Ribble Valley Borough Council
By email

Your ref 3/2024/0484
Our ref DC/24/2254
Date 06-NOV-24

Location: Ramsgreave Bakery Pleckgate Road Ramsgreave BB1 8QW

Proposal: Proposed demolition of existing warehouse structure and erection of two separate blocks of industrial units comprising one block of five units, each with a mezzanine floor and one block of two units each with a mezzanine floor, including associated car parking and service yard

Site Plan - as proposed, scale 1=200

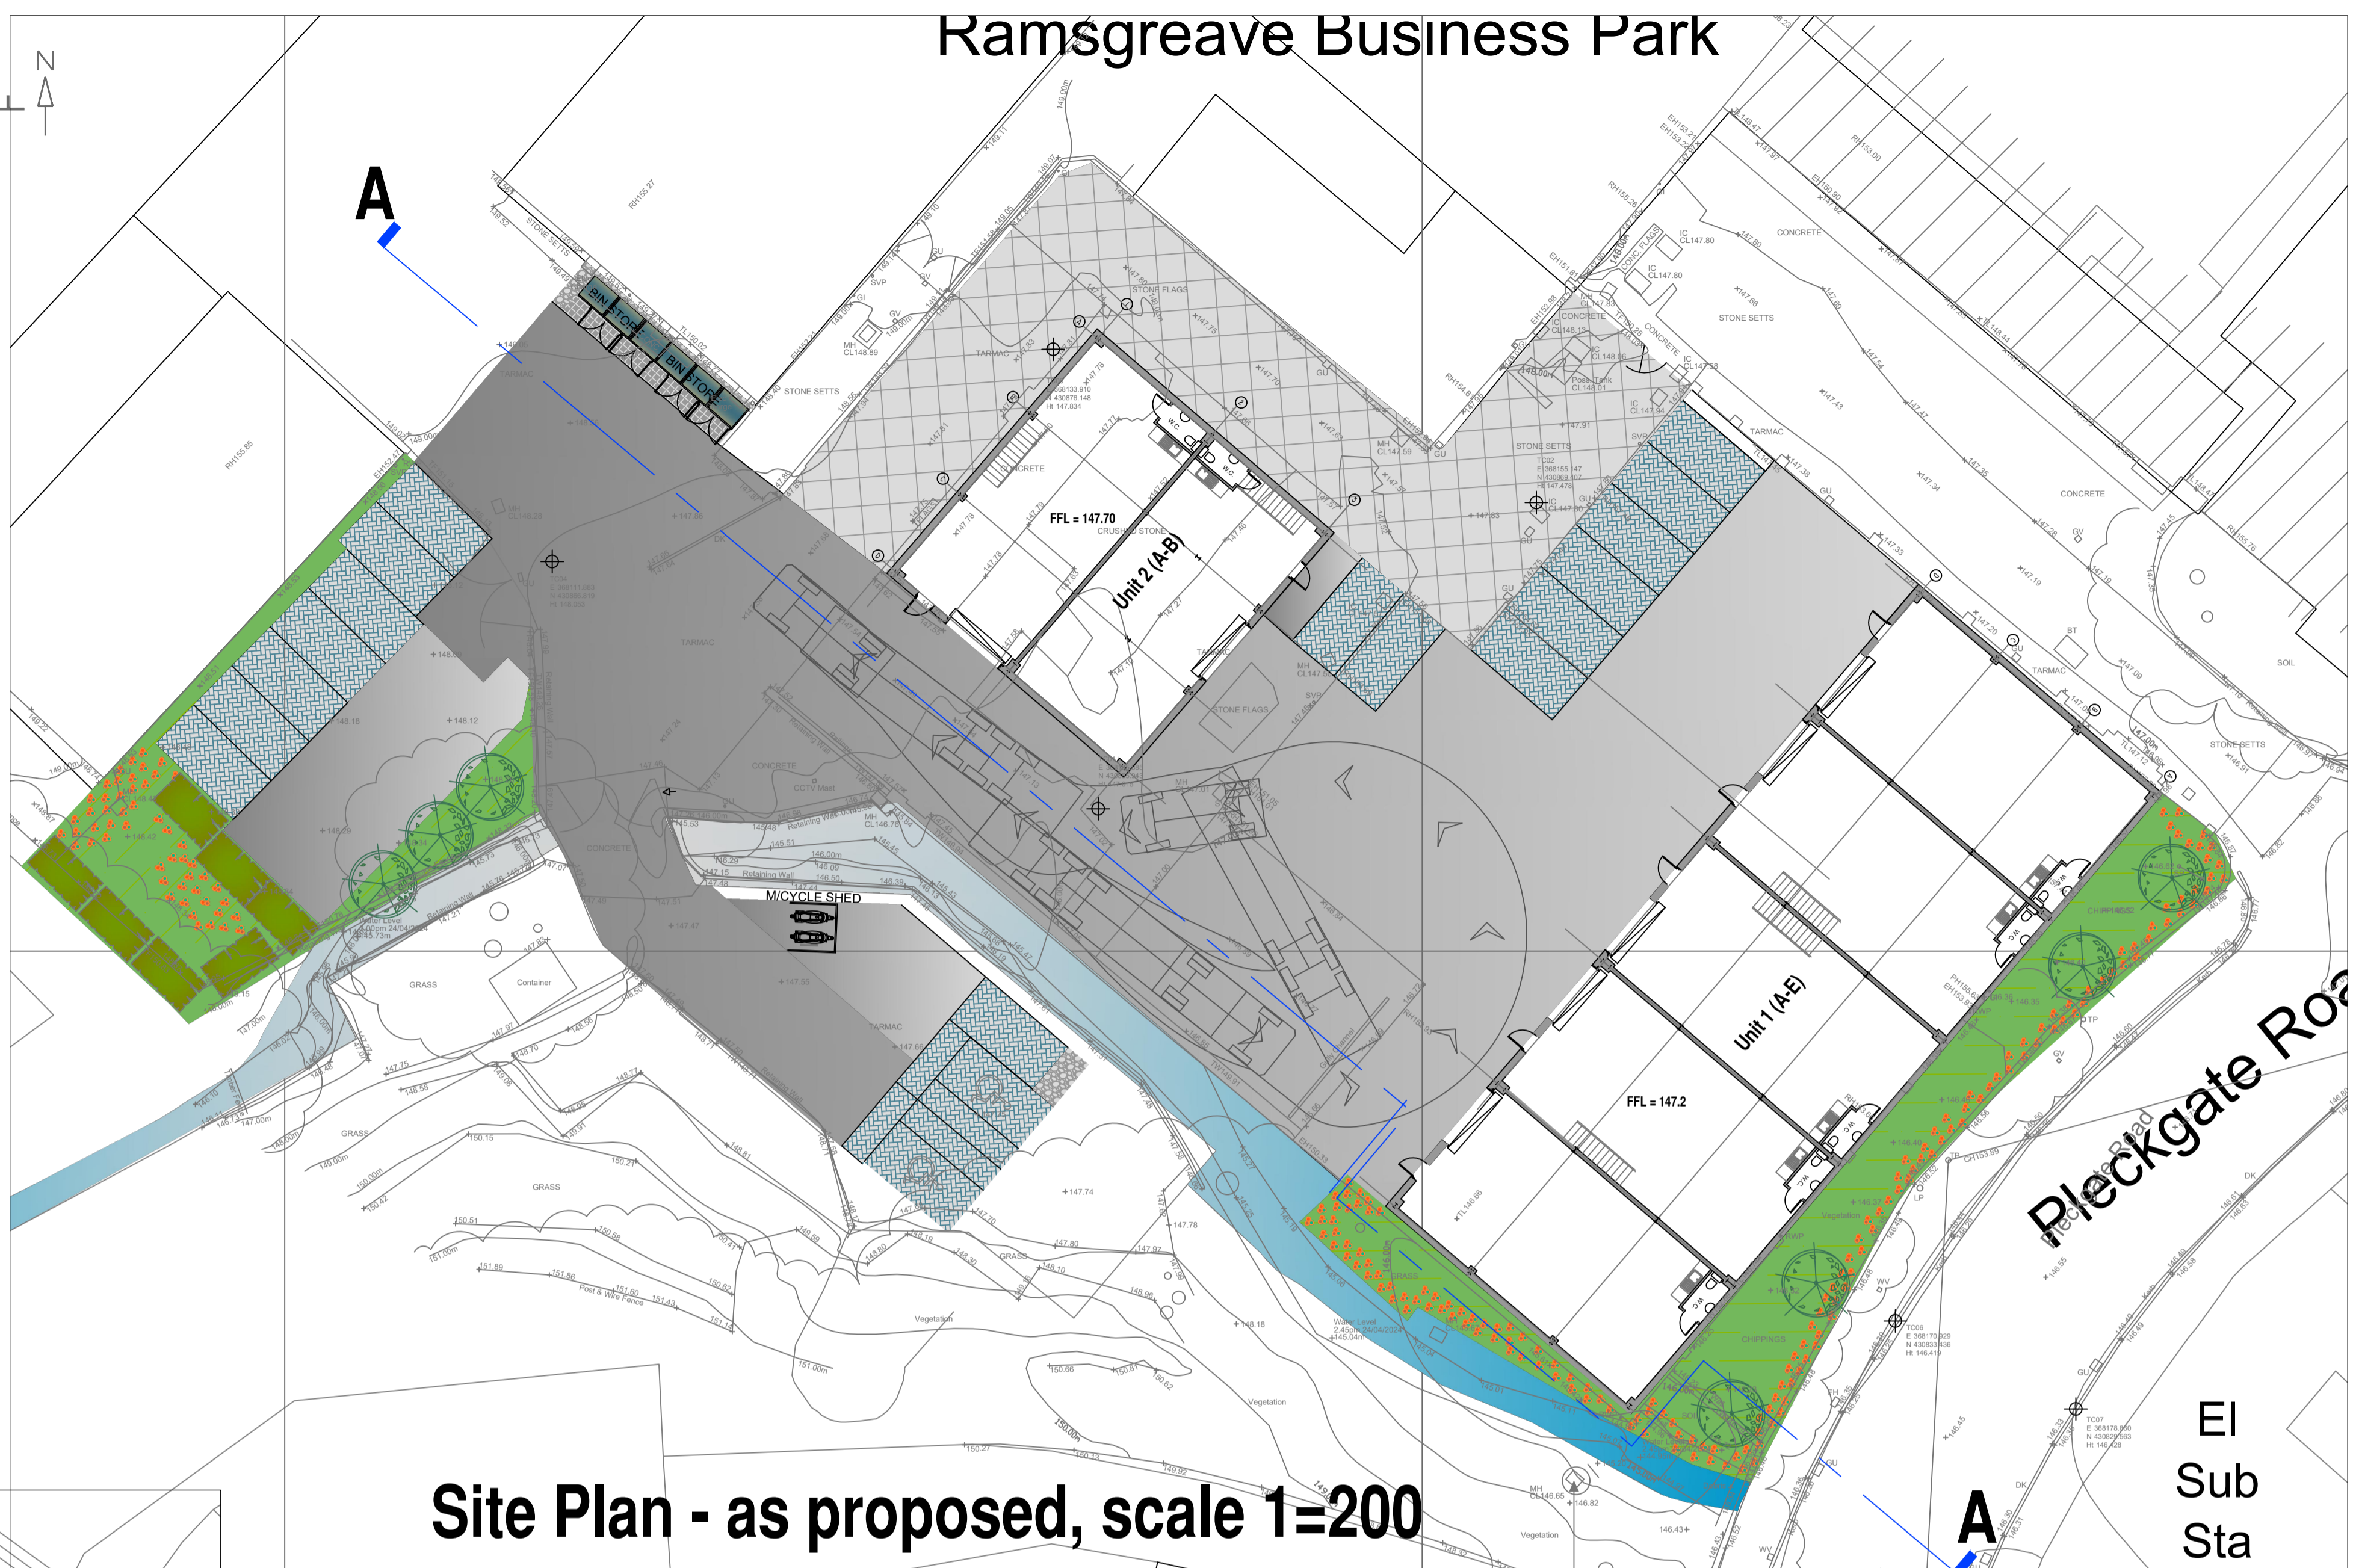
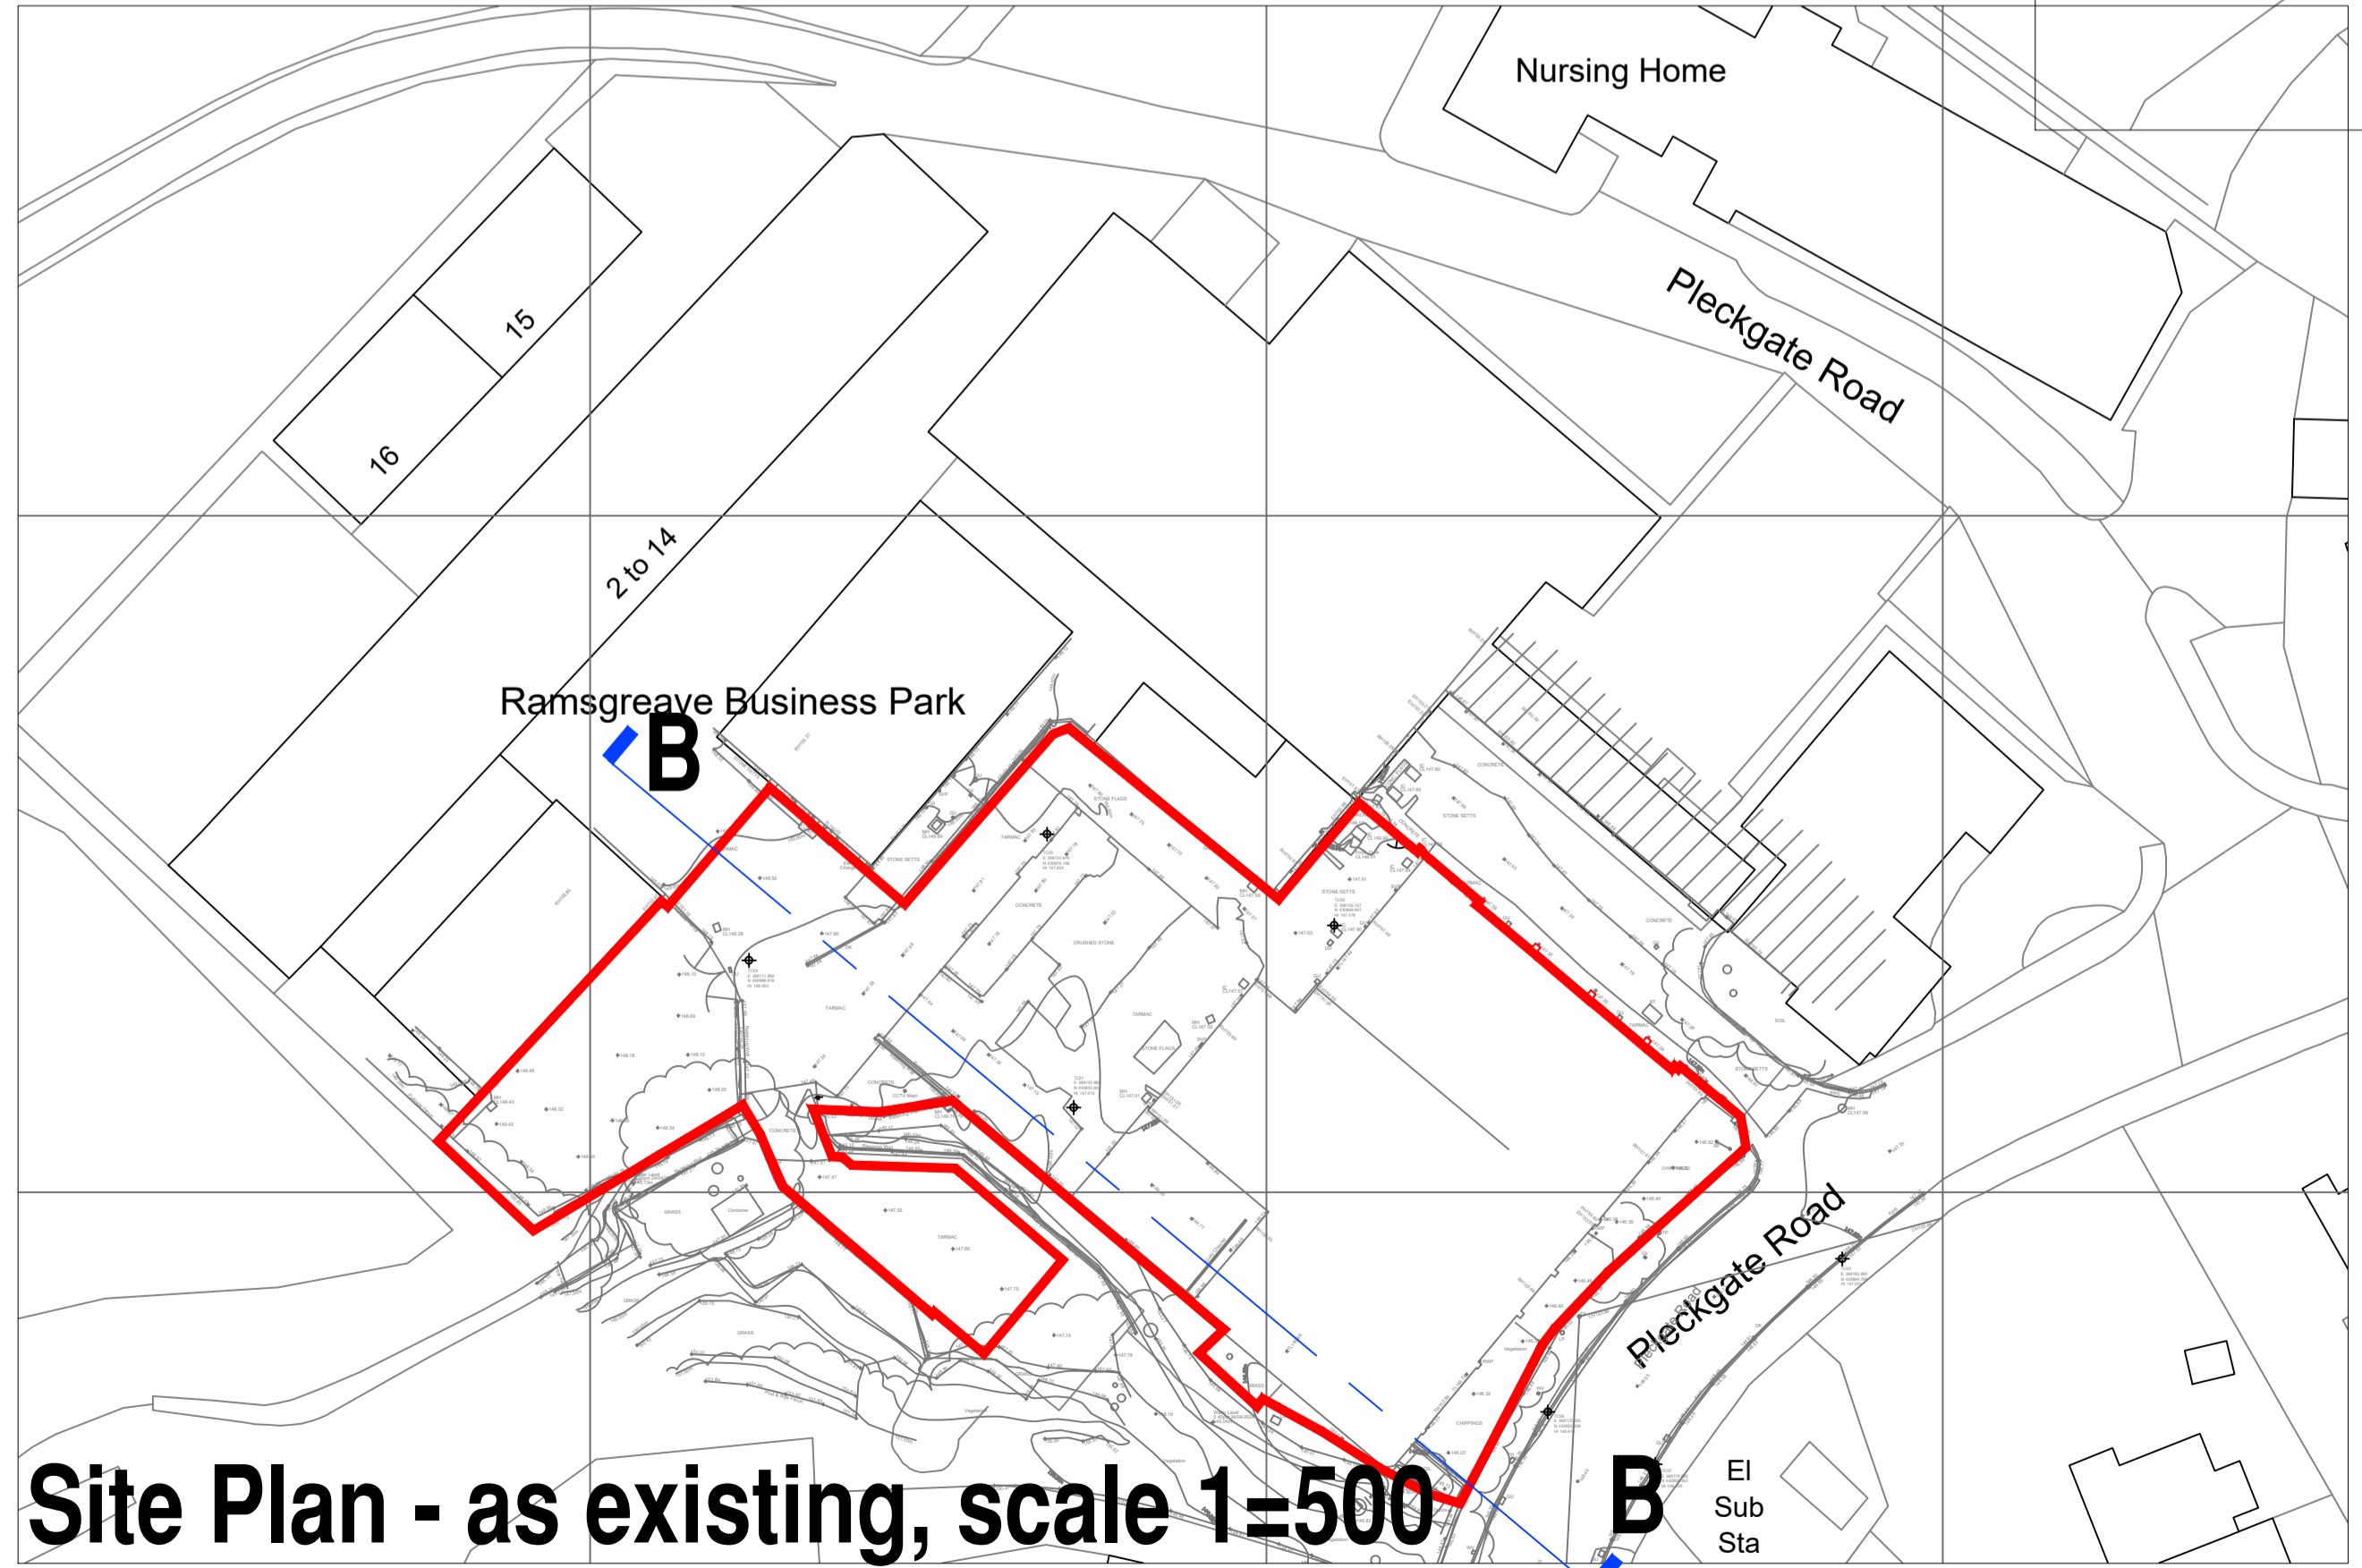
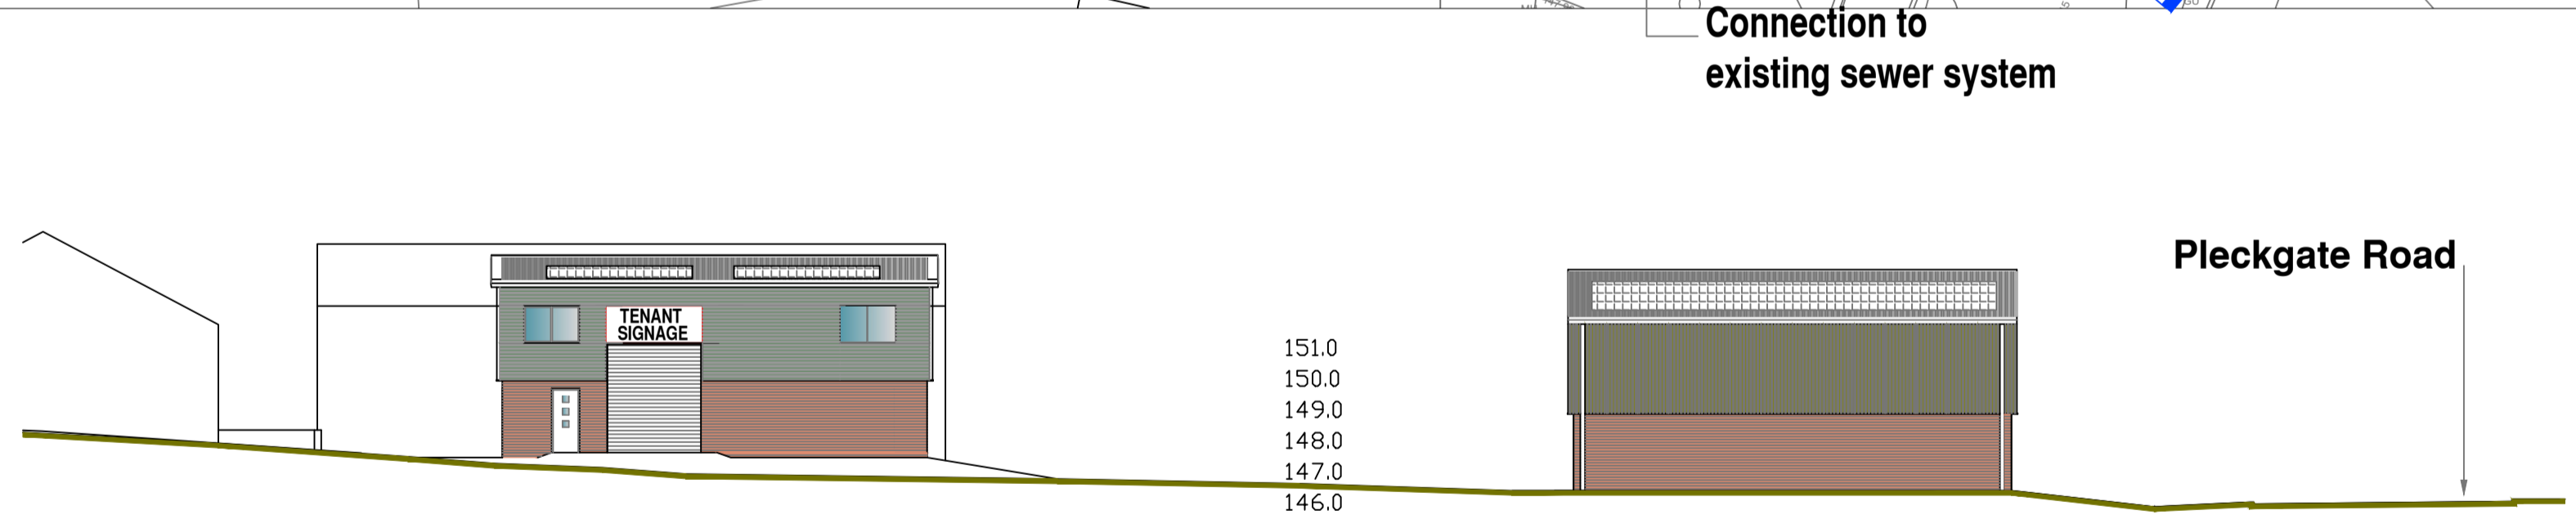
Noting this is a Full application, we request that the applicant provides a detailed drainage plan, and that United Utilities has the opportunity to review and comment on this plan PRIOR TO DETERMINATION of this application.

A water main is located in the vicinity of the site red boundary. It must not be built over, or our access to the pipeline compromised in any way. We require an access strip as detailed in our 'Standard Conditions for Works Adjacent to Pipelines', which can be found on our website: <https://www.unitedutilities.com/builders-developers/your-development/planning/building-over-or-working-near-our-assets/working-near-our-pipes/>. The applicant must comply with this document to ensure pipelines are adequately protected both during and after the construction period.

A public sewer crosses the site and we will not permit building over it. We require an access strip for maintenance or replacement and this access must not be compromised in any way. The minimum distances that might be acceptable to United Utilities are detailed within Part H of the Building Regulations however, we recommend the applicant determines the precise location, size, depth and condition of the pipeline as this is likely to influence the required stand-off distance from any structure.

Prior to the commencement of development, details of a sustainable surface water drainage scheme and a foul water drainage scheme shall be submitted to and approved in writing by the Local Planning Authority. The drainage schemes must include:

- (i) An investigation of the hierarchy of drainage options in the National Planning Practice Guidance (or any subsequent amendment thereof). This investigation shall include evidence of an assessment of ground conditions and the potential for infiltration of surface water in accordance with BRE365;***
- (ii) A restricted rate of discharge of surface water agreed with the local planning authority (if it is agreed that infiltration is discounted by the investigations);***

- (iii) Levels of the proposed drainage systems including proposed ground and finished floor levels in AOD;*
- (iv) Incorporate mitigation measures to manage the risk of sewer surcharge where applicable; and*
- (v) Foul and surface water shall drain on separate systems.*
